REF: 23-02098-OUT

**Location: Begbroke Science Park, Begbroke Hill,
 Begbroke, OX5 1PF**

17 January 2024

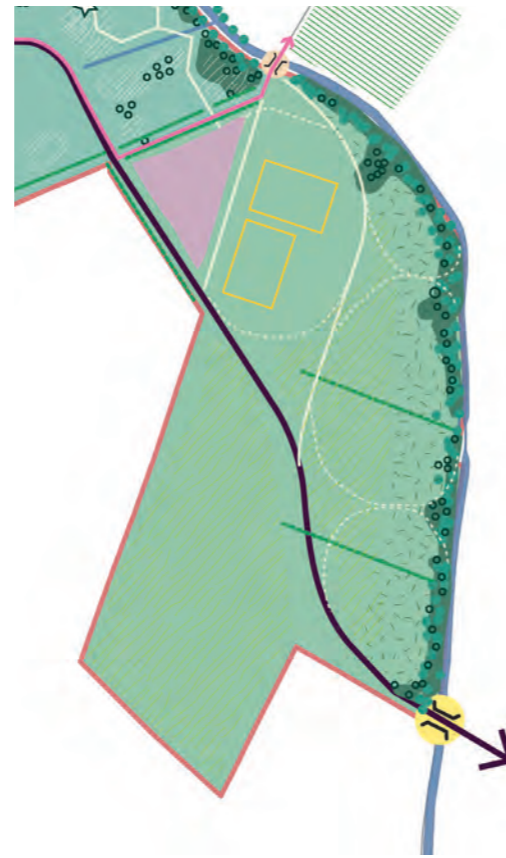
4.14 CS6 / CS7	I recommend adding a requirement for vehicle mitigation measures to prevent unauthorised vehicular incursion (including off road motorcycles).	CS6 requires vehicular access to be kept to an absolute minimum, which is considered an appropriate control for this stage of planning. We will though consider further measures to ensure that unauthorised vehicular access into the park (indeed all landscaped areas) is reasonably restricted.	Noted. Please also note that it is imperative that any car-free residential streets must be very carefully designed to fully prevent unauthorised vehicular entry. Other developments around the country where these types of streets have been proposed have seen constant incidents of residents driving vehicles onto green spaces for convenience and ease of dropping off children, shopping etc. at their front door. The result of which was severely damaged and unattractive green spaces which then significantly detracted from the street scene, that have had to be hard surfaced or otherwise, undermining the entire scheme.
